**ADC Planning Consultation  
Conservation/Design Officer Response**

| <b>Application Number</b> | <b>AB/5/18/PL</b>                                                                                                                                                                                                    |
| <b>Address</b>            | Norton Studio School Lane Arundel BN18 9DR                                                                                                                                                                           |
| <b>Description</b>        | First floor extension & change of use of existing office to form single dwelling. This application may affect the setting of listed buildings & affects the character & appearance of the Arundel Conservation Area. |

Plans and Elevations
Proposed

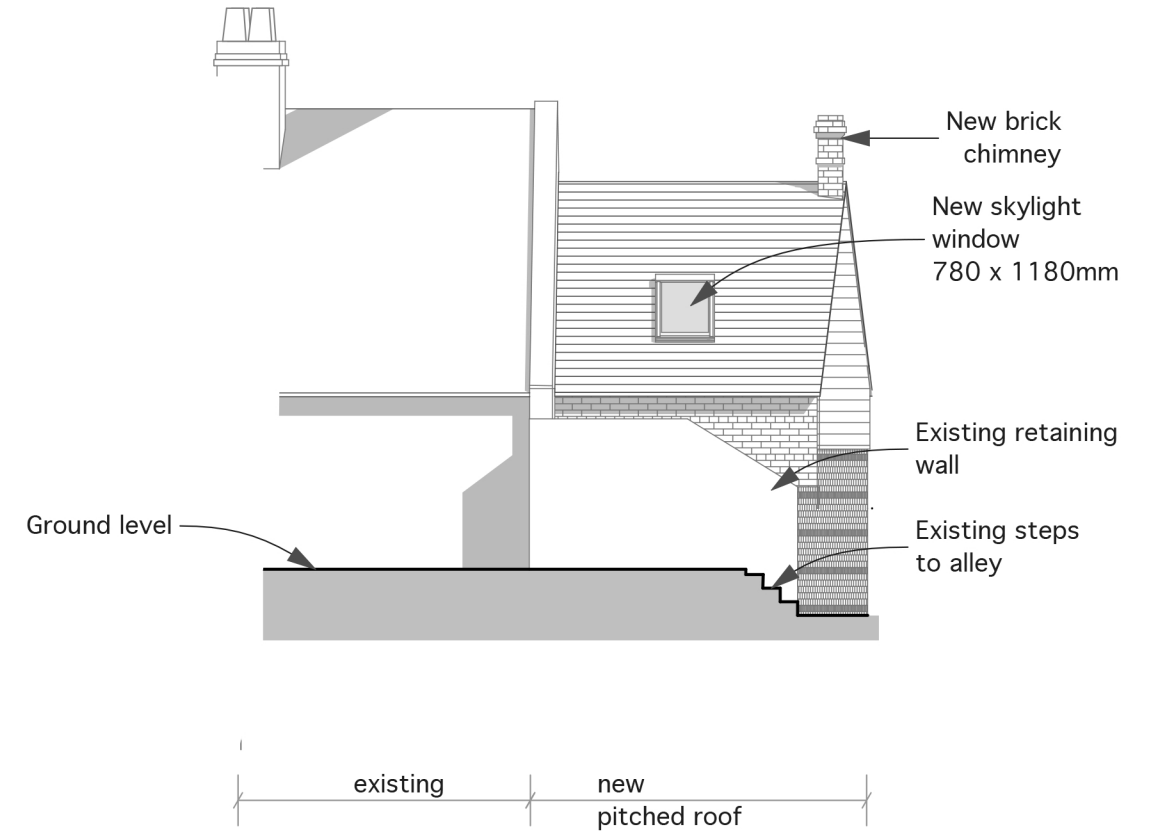
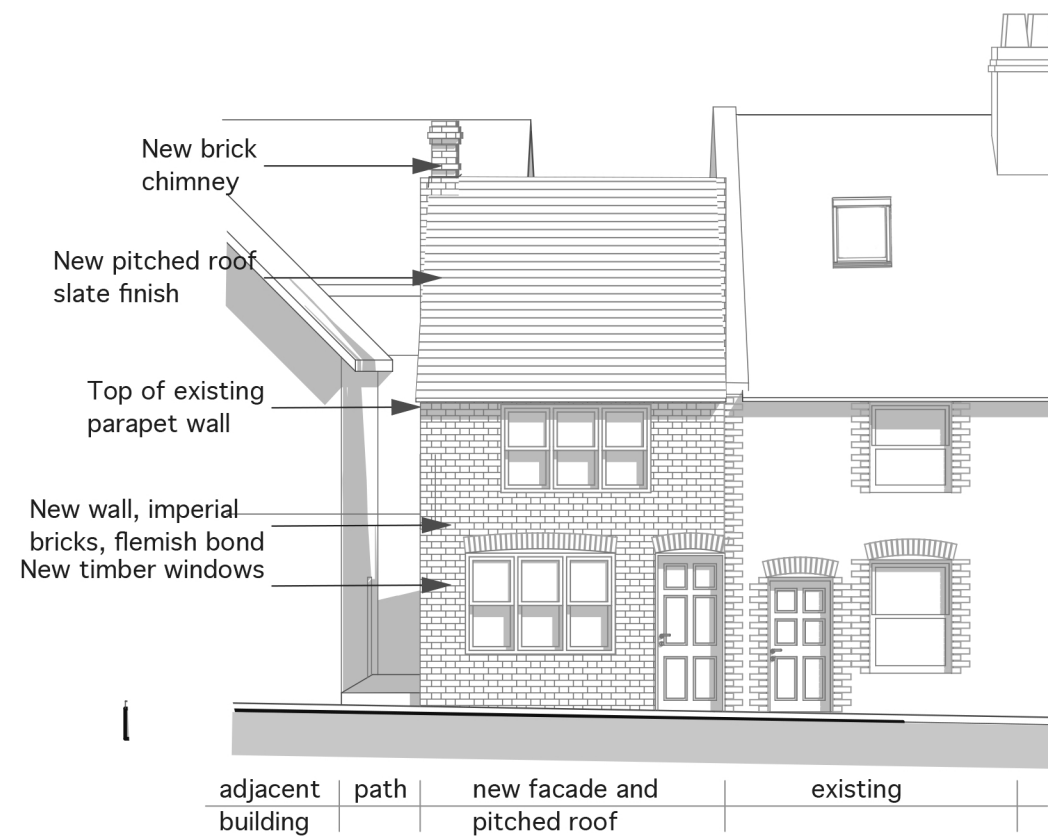
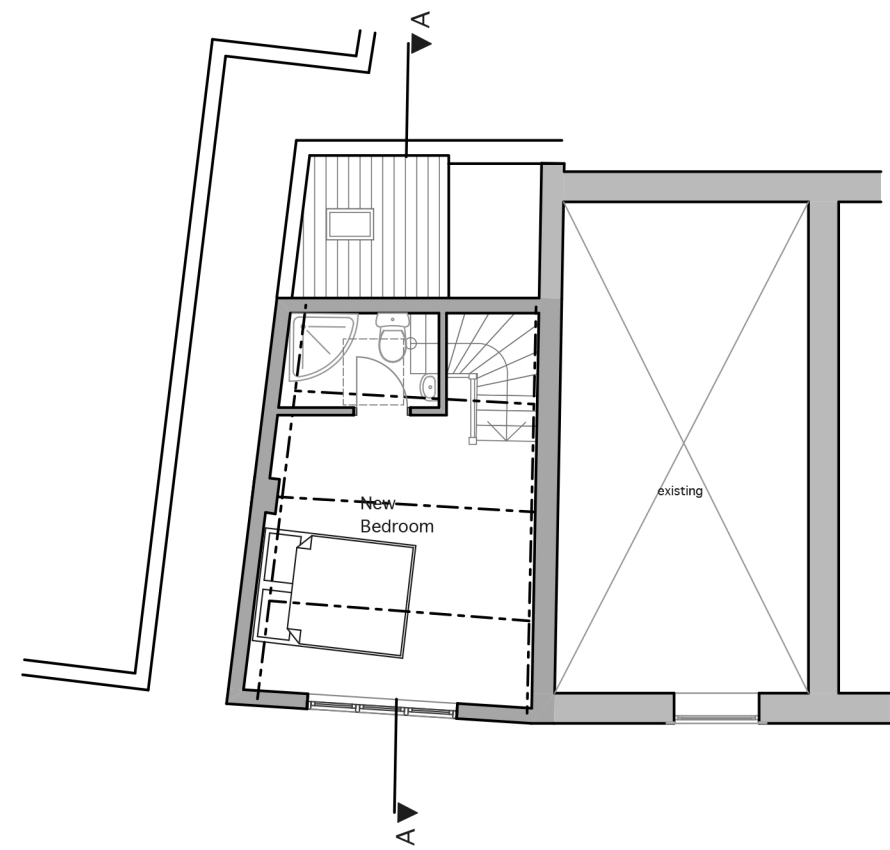
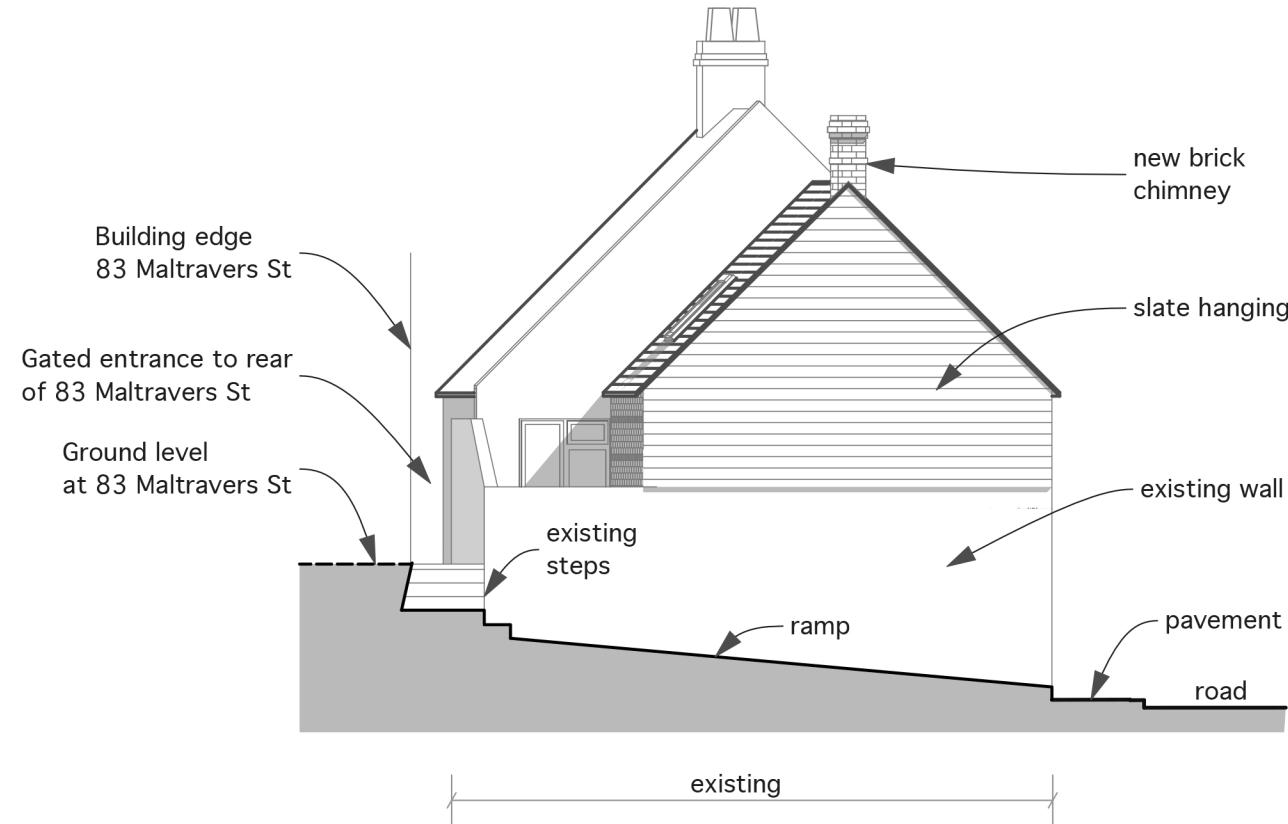
The proposal is described as 'first floor extension', however does not make reference to the removal of the characterful street-facing façade, and would seem to represent demolition of this part of the structure. The current use of studio expresses itself in a distinctive style of fenestration, and its proposed loss is regrettable. School Lane is a mix of residential/school/garage stores etc, and it is considered that the loss of diversity of use would detract from the overall 'backland' feeling of School Lane.

It is recognised that the applicant has approval for extension of the existing shop to achieve a 1 bedroom dwelling over, and that the roofscape of the Approved scheme and the proposed are near-identical. However, it is noted that the proposed roofscape occludes the existing permeable nature of the dwellings and historic gaps between No 4 School Lane and the rear of the range of dwellings along Maltravers St. It is considered that the loss of this loose roofscape and view of the Listed Buildings and Locally Listed buildings would be to the detriment of the character of the Conservation Area.

It is considered that the addition of a new dwelling to the existing pair of cottages, would alter the balance of the existing, non-statutorily listed historic asset, and it would be preferable if the new, proposed dwelling were less dominating (perhaps by the building plane being set back). It is considered that the loss of character, and removal of the previous retail, then office use of the space represents a dilution of character to the Conservation Area.

It is therefore recommended, that as the Applicant has previously achieved permission for an additional storey to the existing office space, that an attempt is made to incorporate the evidence of the existing use is reflected in design to GF level.

It is therefore recommended that the change of use be approved, and if approved be subject to design detail, finishes, fenestration, doors (including door furniture).
